Council Comments (February 2023)	FPA Response	Reference Drawings																																																												
1. Land Use Planning There are discrepancies between the proposed GFA for Stage 1A shown in different area schedules. The area schedule in the Stage 1A Design Report Appendix shows a proposed total GFA of 37,096sqm, the area schedule in Appendix C2 and the Clause 4.6 for Stage 1A has a total GFA of 36,967sqm. These discrepancies need to be addressed.	The proposed Stage 1A GFA is 37,130sqm and has been updated across all documentation. Based on a Stage 1A site area of 18,150sqm, the maximum permissible GFA is 39,930sqm. This comprises application of: - a base FSR of 1.7:1 under the PLEP 2011 resulting in a maximum permissible base GFA of 30,855sqm; and - a bonus FSR of 0.5:1 under clause 6(2) and 1392) of the Affordable Rental Housing SEPP resulting in 9,075sqm. The proposed GFA is 2800sqm below the maximum permissible GFA. Accordingly, a clause 4.6 variation request is not required.	- Stage 1A DA Design Report pg.12, 73, 74, 81 - Stage 1A Telopea Development Schedule <table><tr><td>Site Area (excl RE1)</td><td>18,150sqm</td></tr><tr><td>Base 1.7:1 FSR</td><td

HEIGHT PLANE DIAGRAM

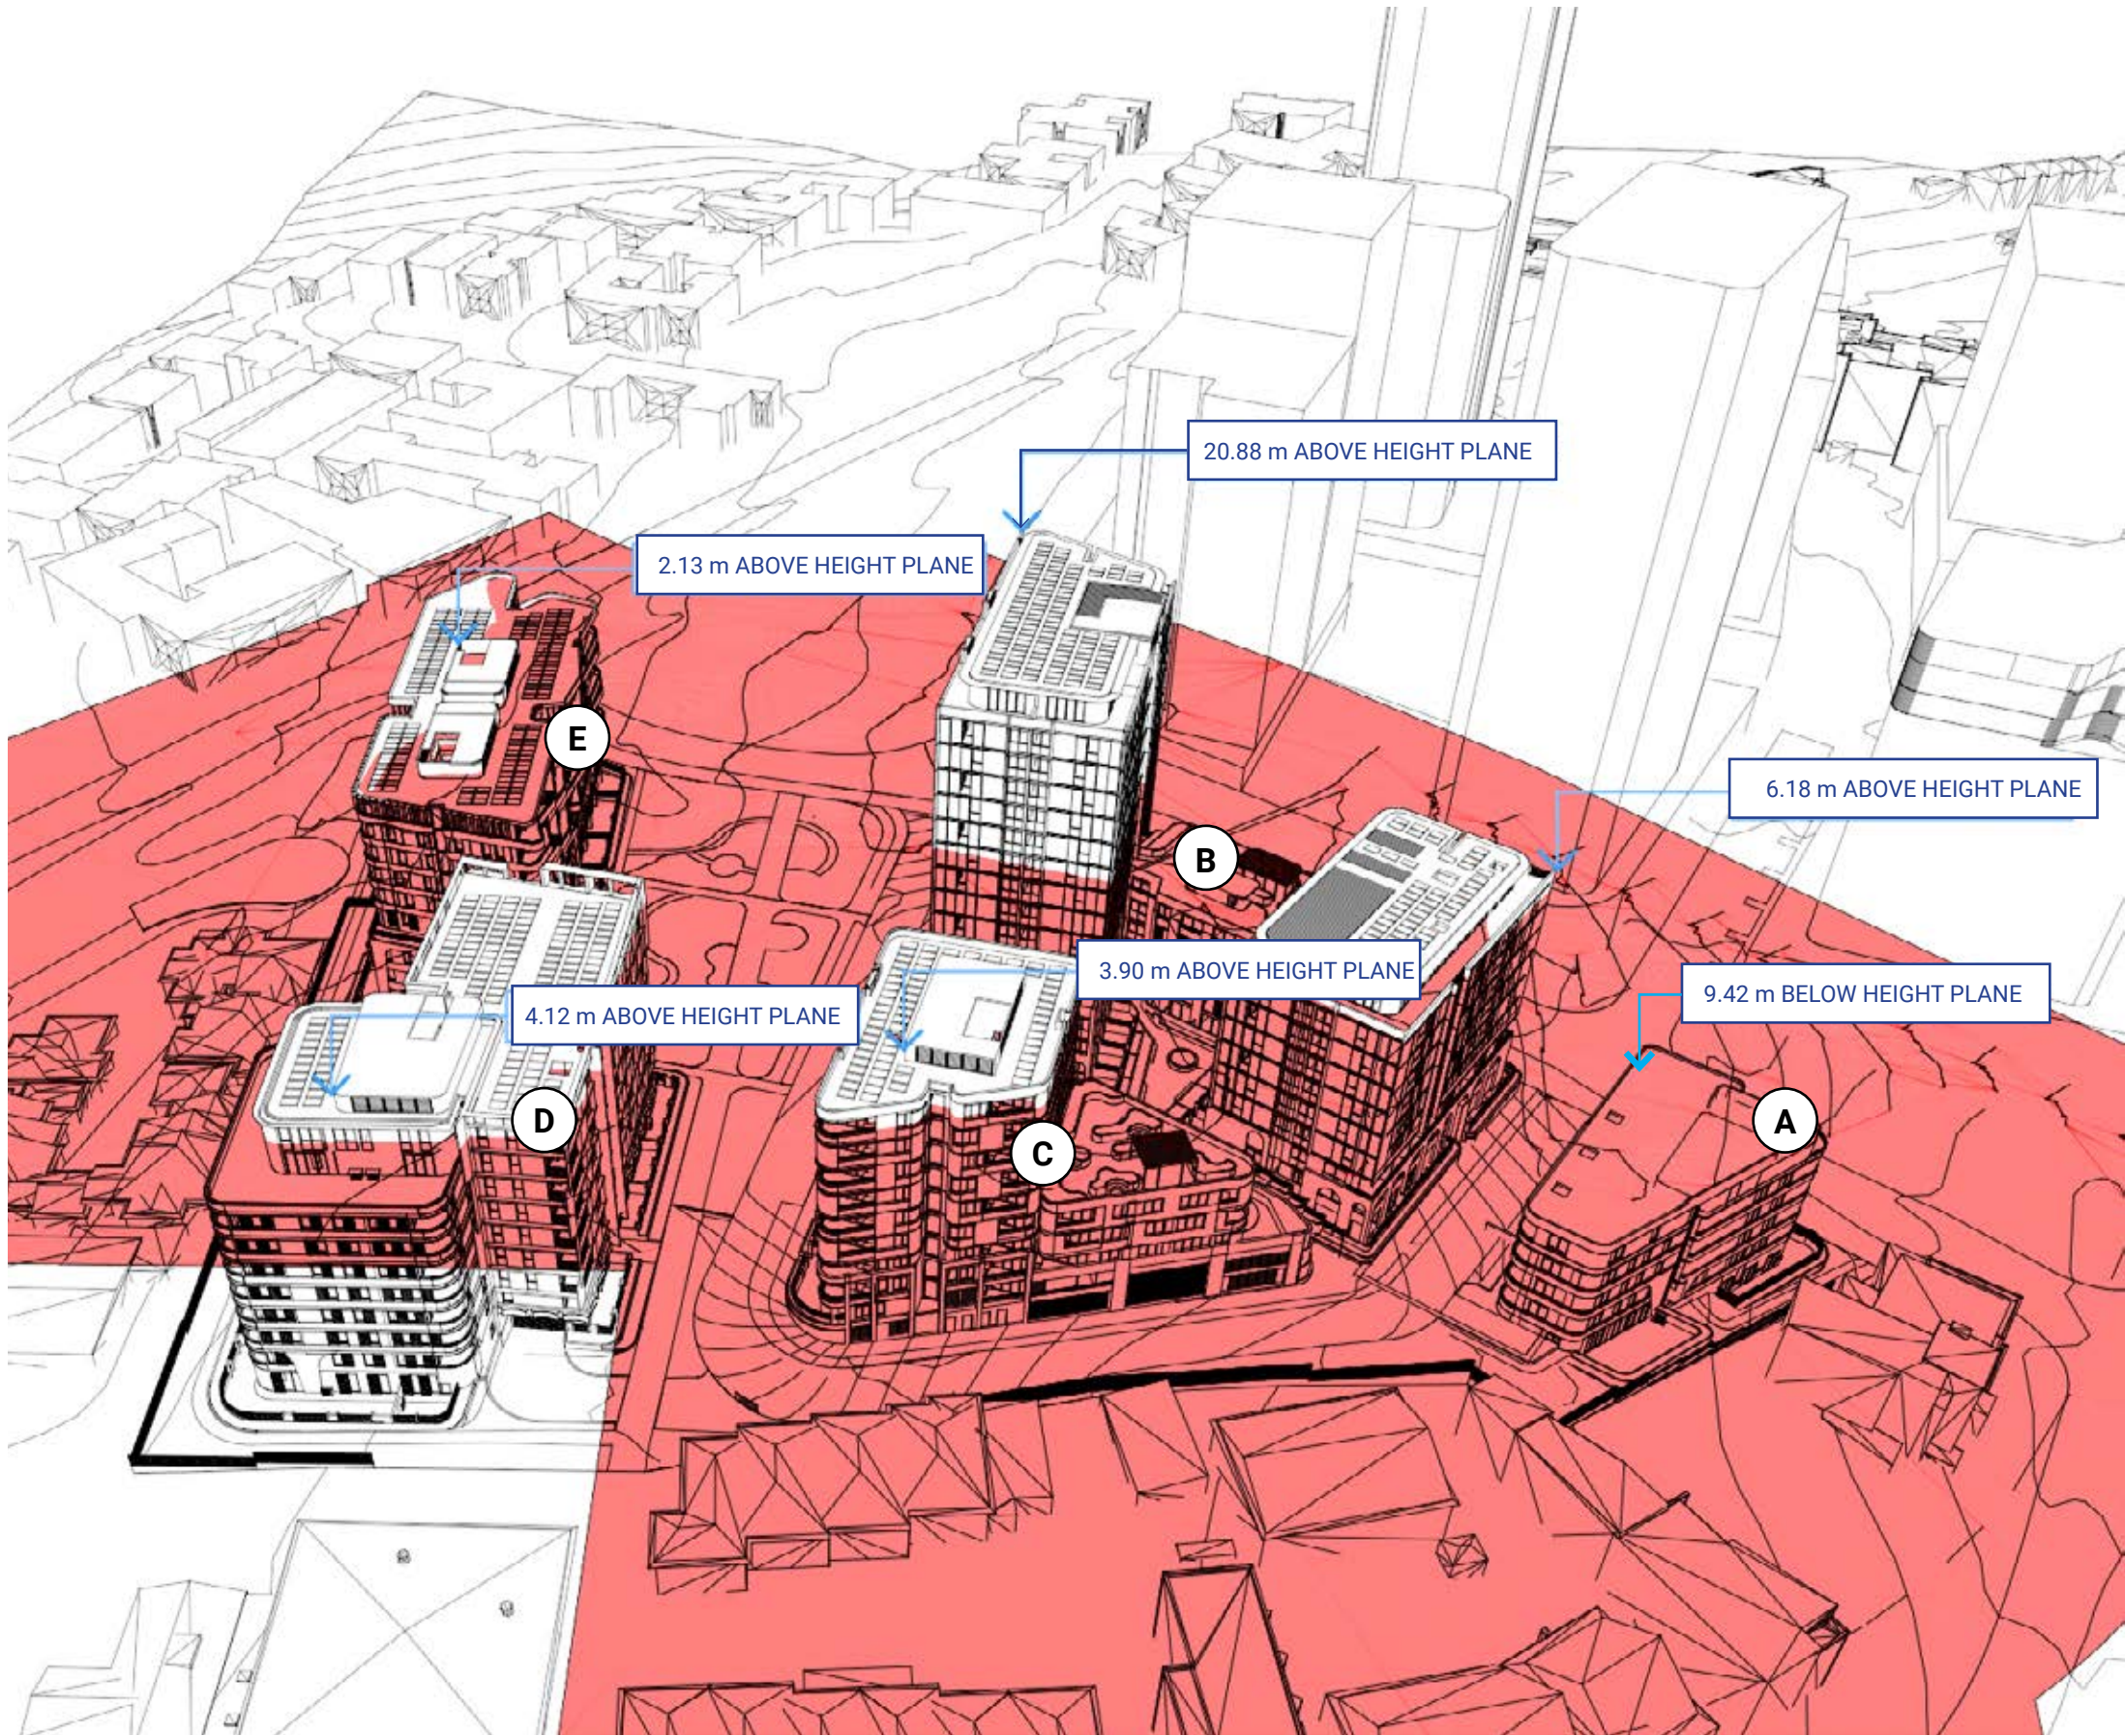
Telopea Masterplan envisaged a 9-storey height to the Stage 1A area. Building B and D, at 10 and 15 storeys respectively, is not in line with this vision. As such, any additional height increases are not supported, especially when it results in buildings that exceed the maximum height limit control in PLEP 2011. It is important to manage the height within the Stage 1A area to distinguish it from the denser Core on the other side of	Taller buildings within the Stage 1A Project Application site are the direct result of the SDRP process. In particular the SDRP voided feedback to the project team encouraging: <i>opportunities for a broader range of architectural expression should be investigated and these could include..... avoiding generic outcomes through appreciation of and emphasis on local character....greater height variation across the precinct –</i>	• Stage 1A DA Design Report pg.18, 20, 23, 25 • Scale Transition Diagram

<i>*Proposed height is approximated due to the complexity of the sloping terrain.</i> Building A sits well below the maximum permissible building height under PLEP 2011 (6m below the maximum height limit).	Building	PLEP 2011 Maximum Height (m)	Stage 1A Project Application Proposed Height (m)	Variance Approx (m)	Variance (%)	Building A	28m	18.58m	-9.42m	-33.6%	Building B	28m	48.88m	+20.88m	+74.5%	Building C	28m	31.90m	+3.90m	+13.9%	Building D	28m	32.12m	+4.12m	+14.7%	Building E	28m	30.13m	+2.13m	+7.6%	Due to the sloping terrain, buildings contain few sleeve apartments on lower ground levels which can be read as a storey higher at the boundaries. These buildings, however, are largely perceived as the storeys nominate in the diagram.
Building	PLEP 2011 Maximum Height (m)	Stage 1A Project Application Proposed Height (m)	Variance Approx (m)	Variance (%)																												
Building A	28m	18.58m	-9.42m	-33.6%																												
Building B	28m	48.88m	+20.88m	+74.5%																												
Building C	28m	31.90m	+3.90m	+13.9%																												
Building D	28m	32.12m	+4.12m	+14.7%																												
Building E	28m	30.13m	+2.13m	+7.6%

PLOT DATE
14/09/2023
CHECKED
RP
DRAWING NO.
PLA-AR-DA0350

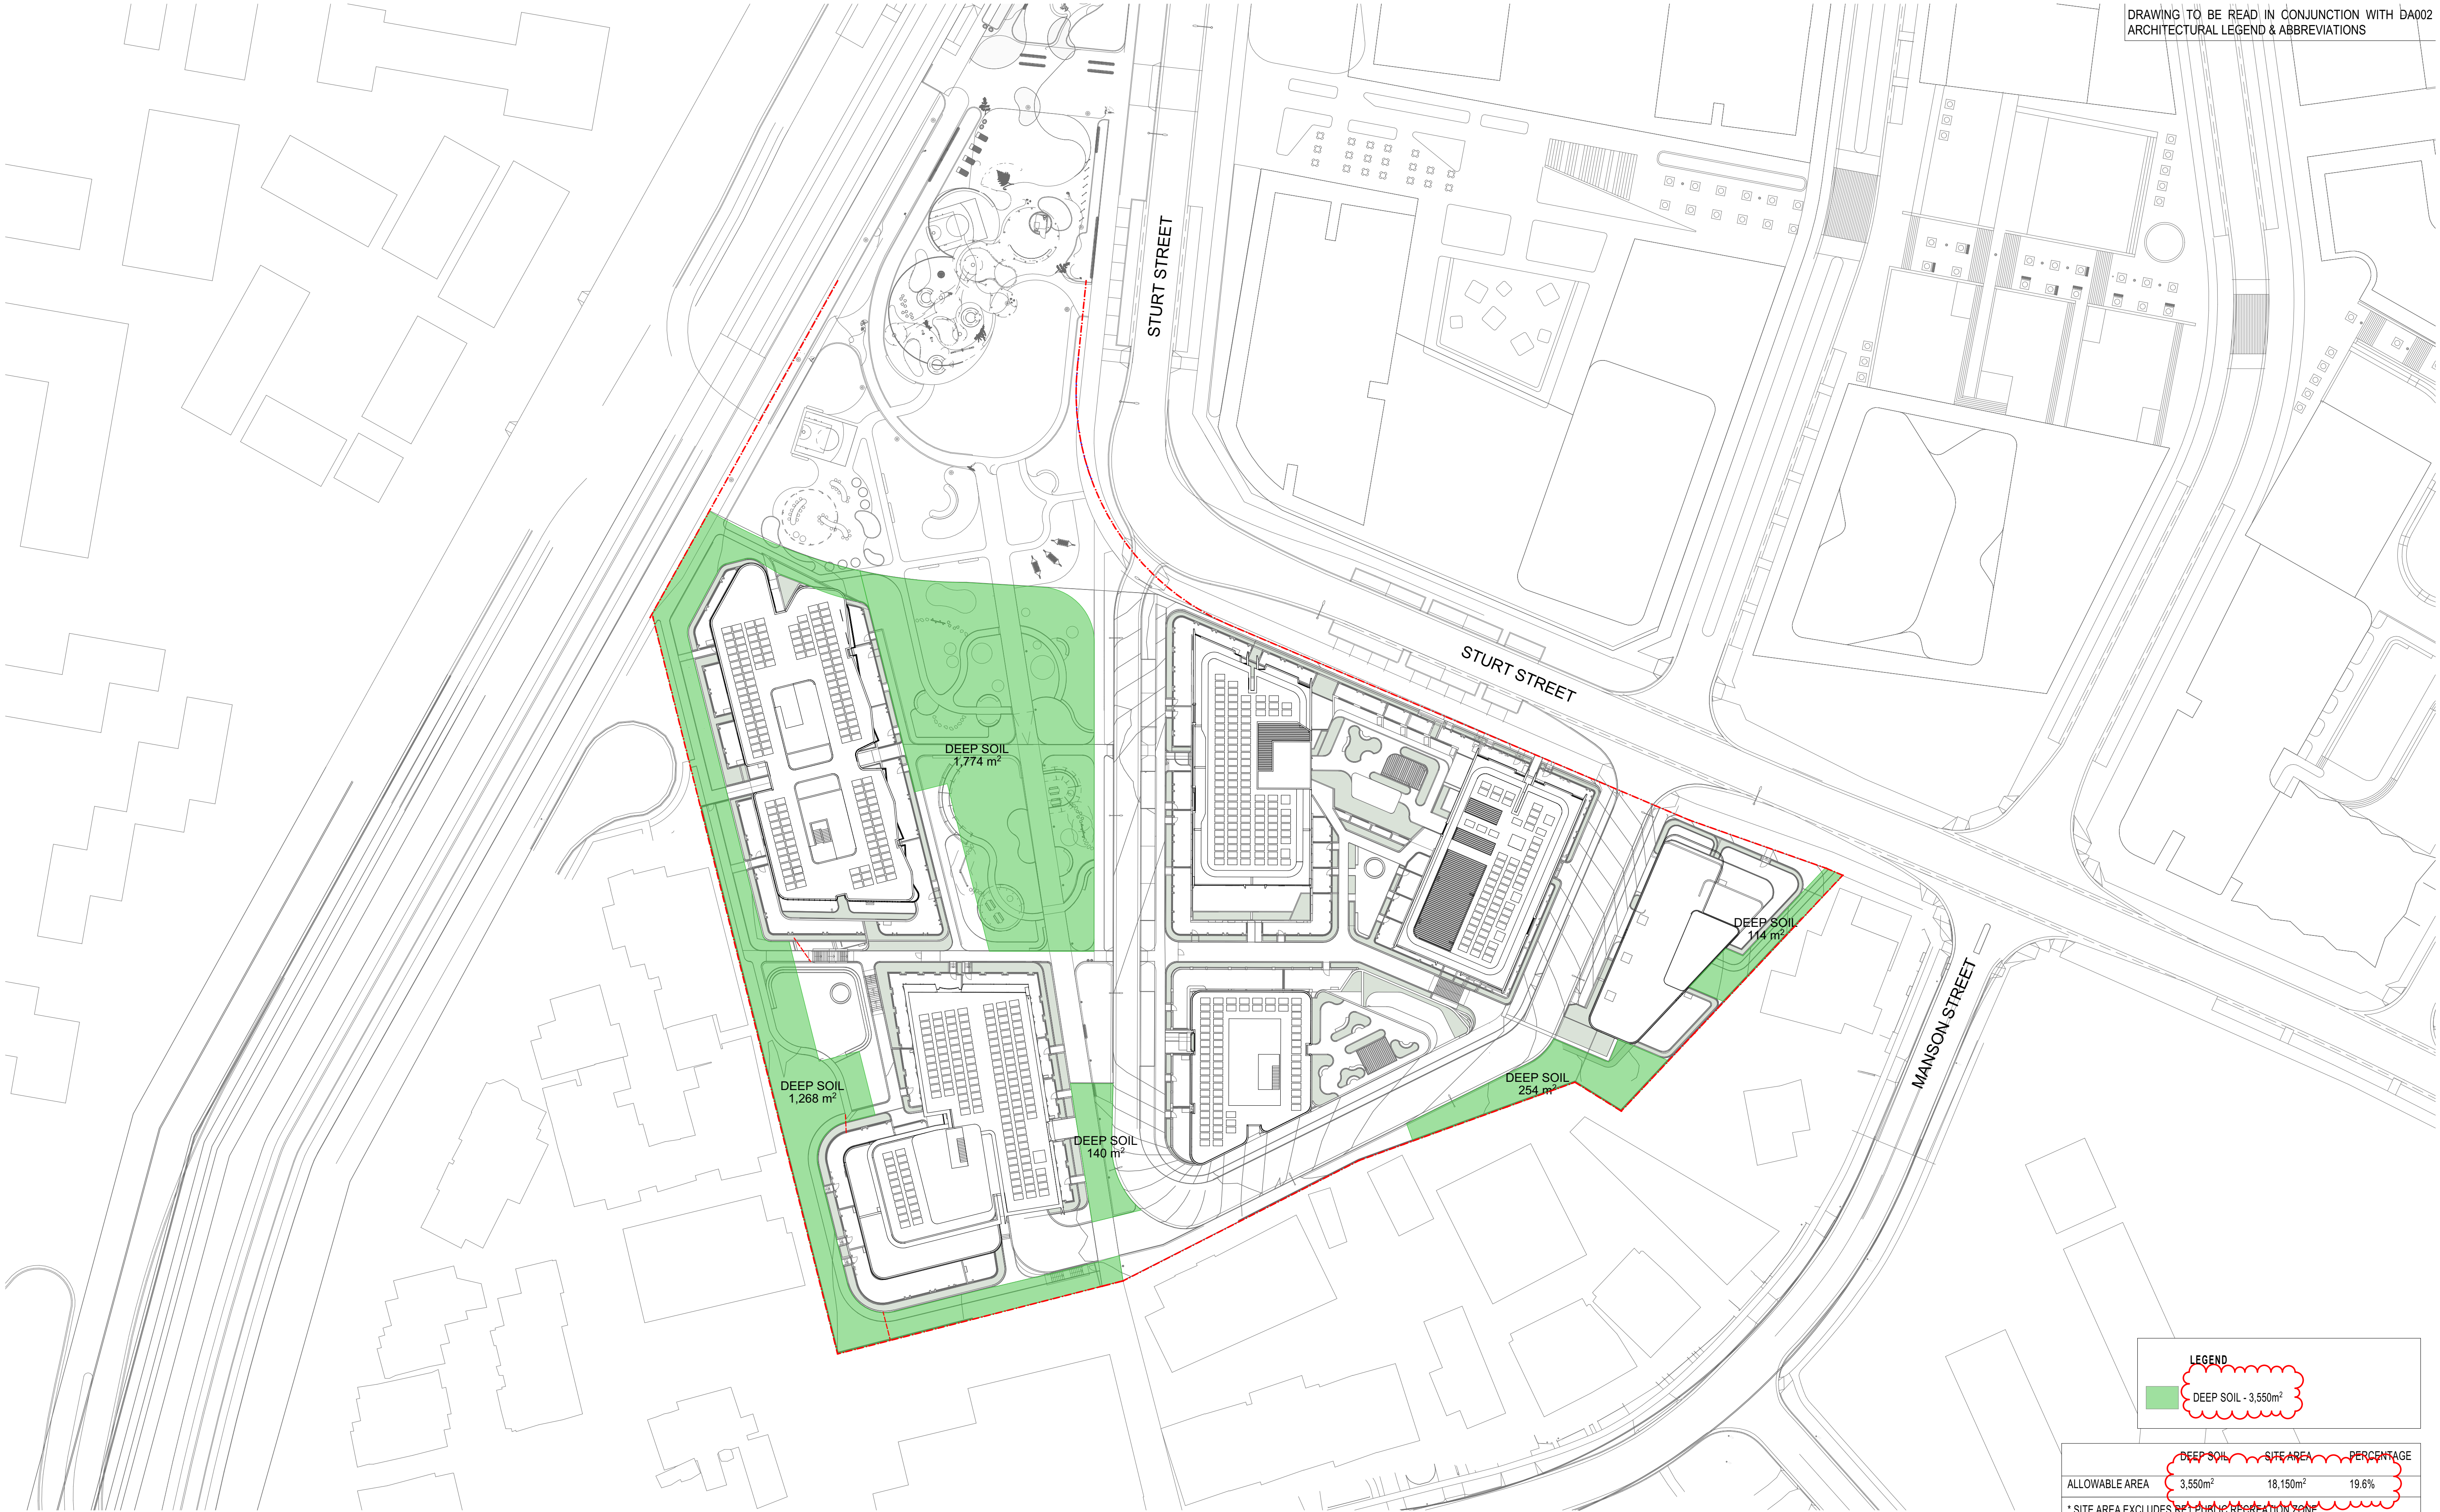
4. Urban Design		
Council does not agree to a consent being issued without a VPA. It is in the interest of both parties to resolve the VPA prior to any consent being issued. A substantial number of items are part of the Stage 1A application and are still outstanding in terms of design and approvals from TfNSW. Council notes the importance of a timely resolution of the matter and is committed to working with Frasers and LAHC to endorse a draft Planning Agreement prior to any consent being issued for the SSD.	N/A for the purposes of the Design Competition Waiver Request	N/A for the purposes of the Design Competition Waiver Request
Communal open space must be provided for buildings C7, C8 and Building A (Stage 1A) and identified in plans	Approximately 327sqm of communal open space is allocated to Building A. Building A's site area is 1,092sqm and consequently the proposed communal open space equates to 29%	- Stage 1A DA Design Report pg.12. - PLA-AR-DA0350 DEEP SOIL CALCULATION
